MEMORANDUM

TO: Molly Casto
FROM: Dan Goyette, PE, and Lauren Swett, EIT
DATE: December 4, 2007
RE: Estates of Longfellow Inn

Woodard & Curran has reviewed the site plan submission for The Estates of Longfellow Inn. The project proposes to renovate and add to an existing multifamily residential building located at 130 Eastern Promenade in Portland. The garage for the existing building will be demolished and replaced with paved parking, and an expansion will be added to the building to provide room for seven units.

DRAINAGE IMPROVEMENTS PLAN
THE ESTATES OF LONGFELLOW INN
130 EASTERN PROMENADE
PORTLAND
MAINE
SCALE: 1"=20'
C.I.: 1'
DATE: 11/19/07

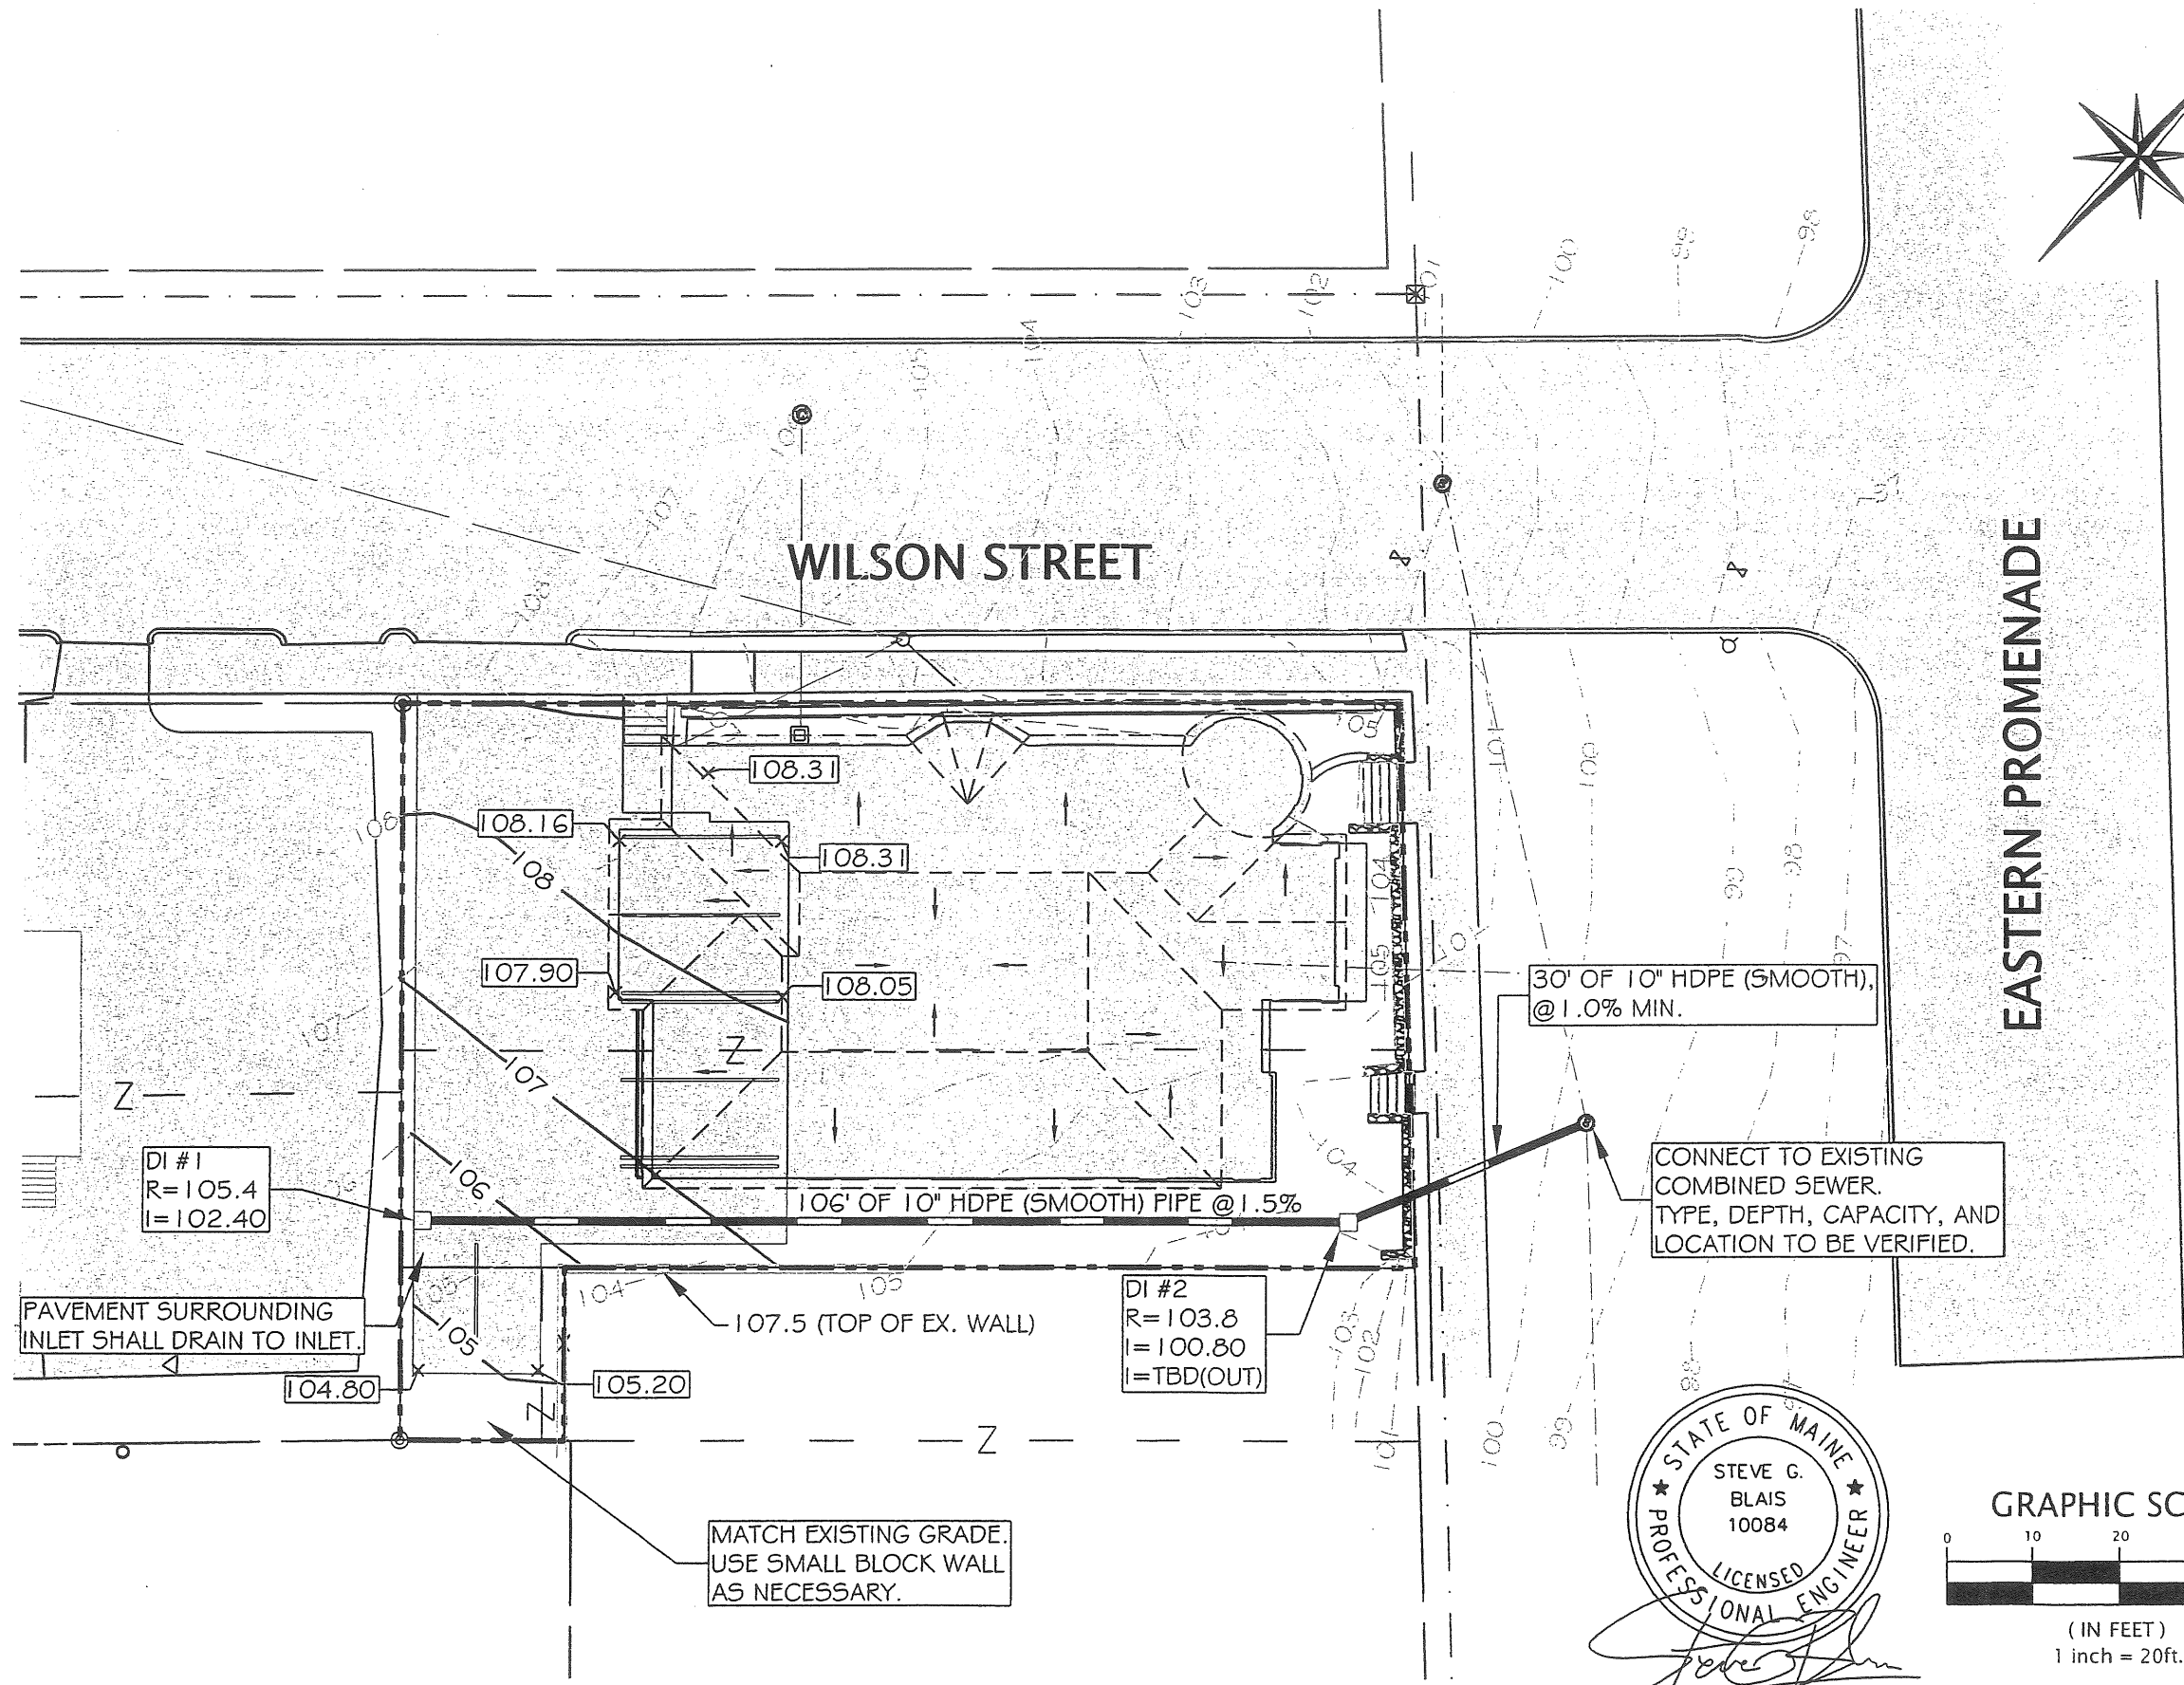
- All drain inlet structures for the project should be catch basins with 3' sumps and casco traps.
- The piping connecting DI #1, DI #2, and the sewer manhole in the esplanade is called out as HDPE (smooth). This piping should be SDR 35 PVC sewer pipe.

EXISTING CONDITIONS SURVEY
 THE ESTATE OF THE LONGFELLOW INN
 AT 130 EASTERN PROMENADE, PORTLAND, MAINE

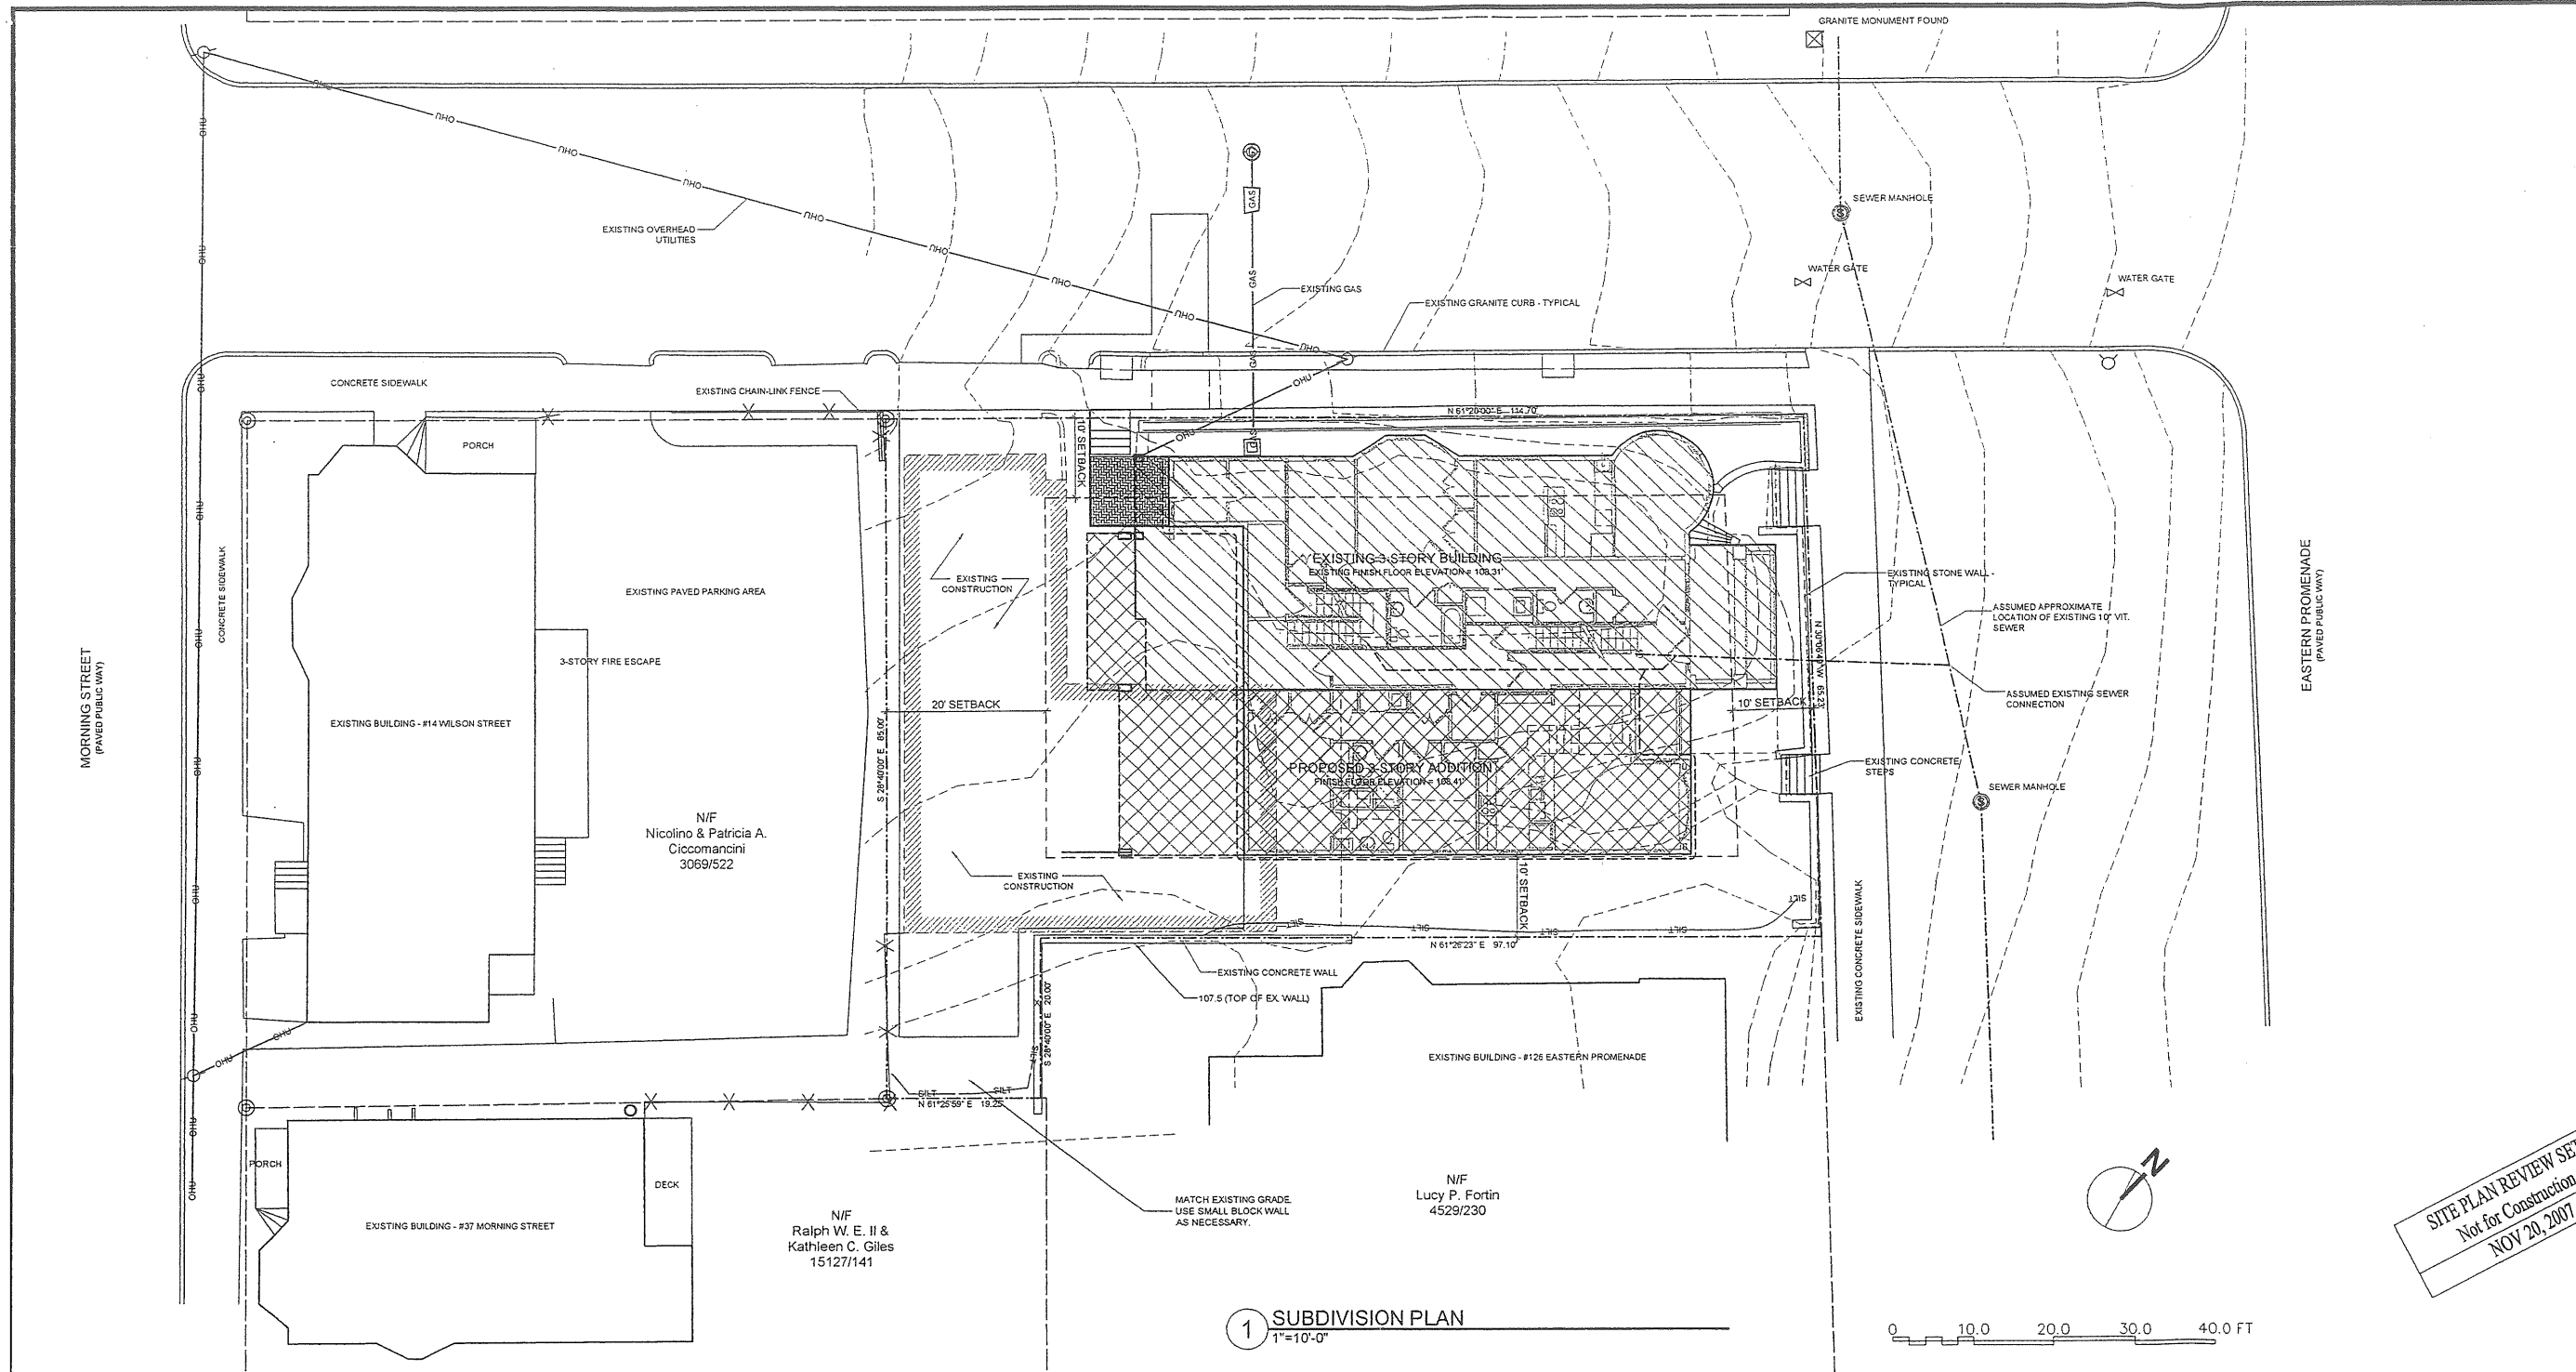
- The applicant should confirm that the survey for the project coincides with approved City standards. The survey needs to be tied to the vertical datum of NGVD 1929. Also, the project needs to be tied to the Maine State Plane Coordinate System (2-zone projection), West Zone using the NAD 1983 (HARN) Datum and the U.S. Survey Foot as the unit of measure. These items should be indicated in the general notes provided on the survey.

C1.2

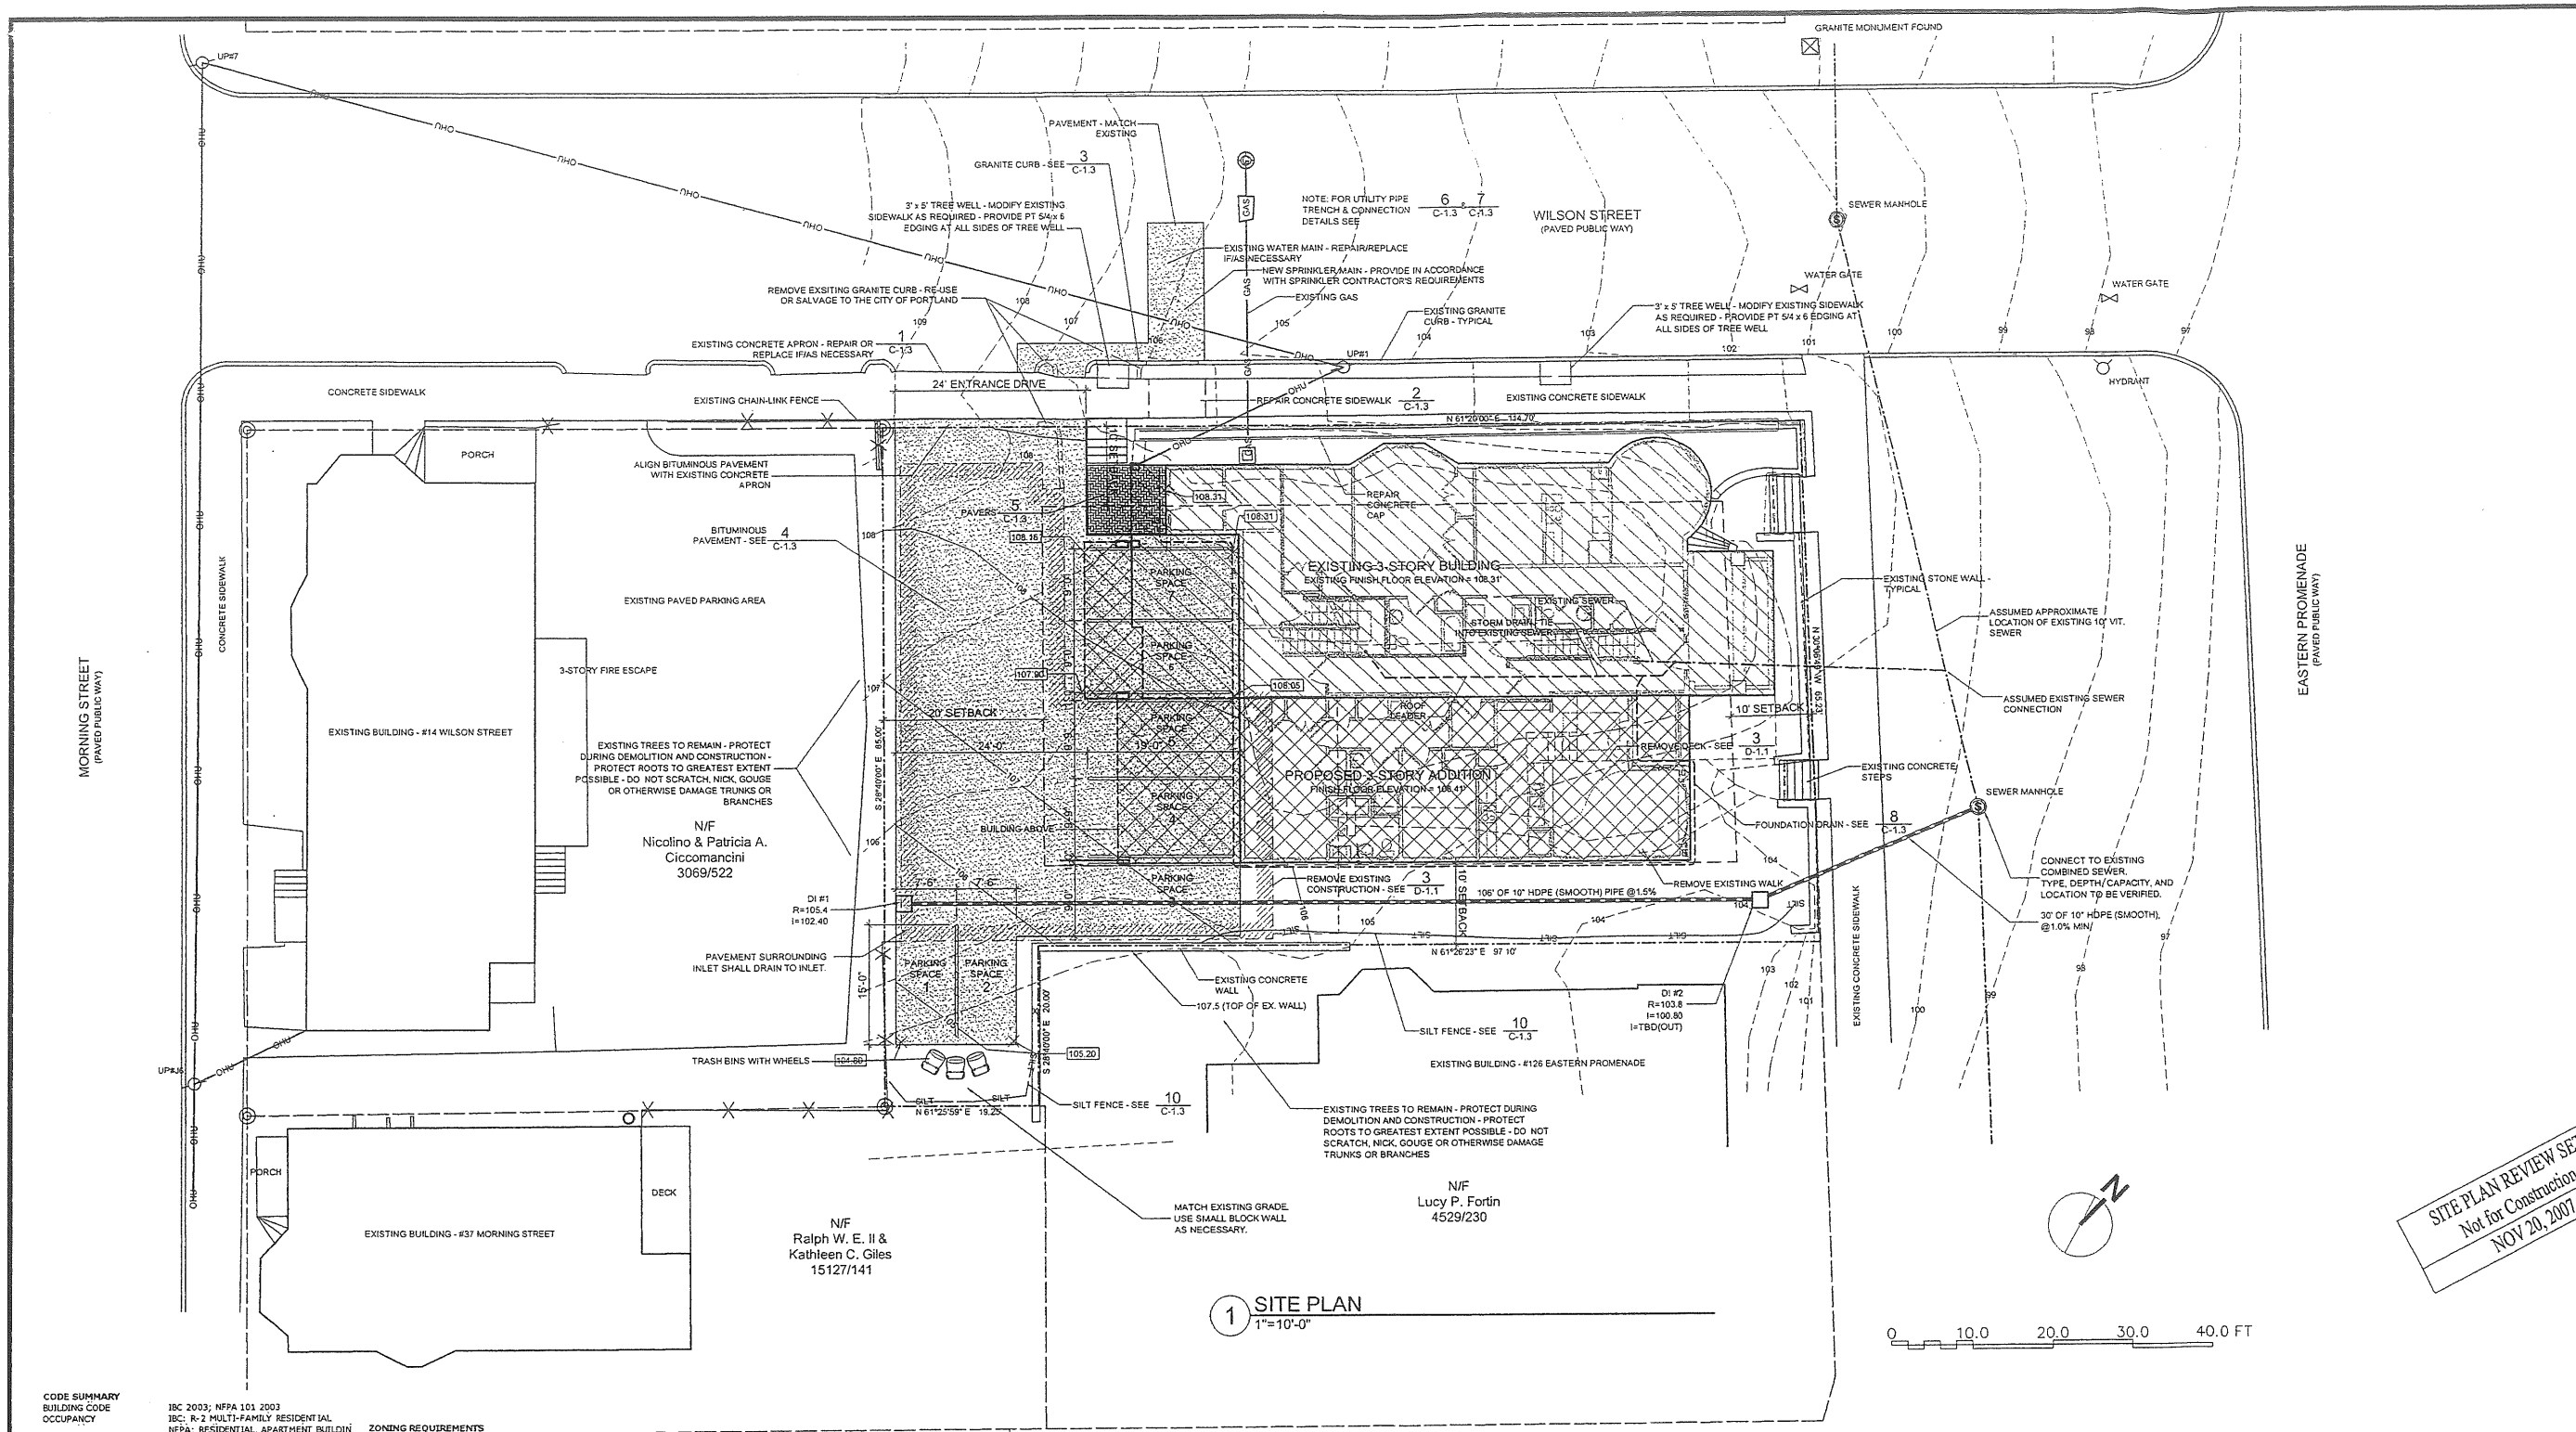
- An engineering details sheet was not included with this submission. This sheet should include details showing conformance with City of Portland design standards for items including pavement, curbing, utility structures and connections, pipe trenching, and erosion control. The site plan references details on Sheet C1.3, which was not included in this submission.

- No work will be allowed in the R.O.W. until the Moratorium for the street has been lifted, and weather permits construction.
- Parking spaces 1 and 2 do not meet the City of Portland design standards. Parking spaces should have a depth of 19' and a width of 9'.

- The site plan shows the location of water gates, however the water line itself is not shown.
- The stormwater report shows that there will be a slight increase in flow for the post development site conditions. In addition, the possibility of connecting roof leaders into the stormwater system was referenced in the report. The capacity of the existing combined sewer system, and the effect of the proposed project's stormwater and sanitary sewer flows on the system needs to be verified and taken into account in the design prior to the approval of the project.
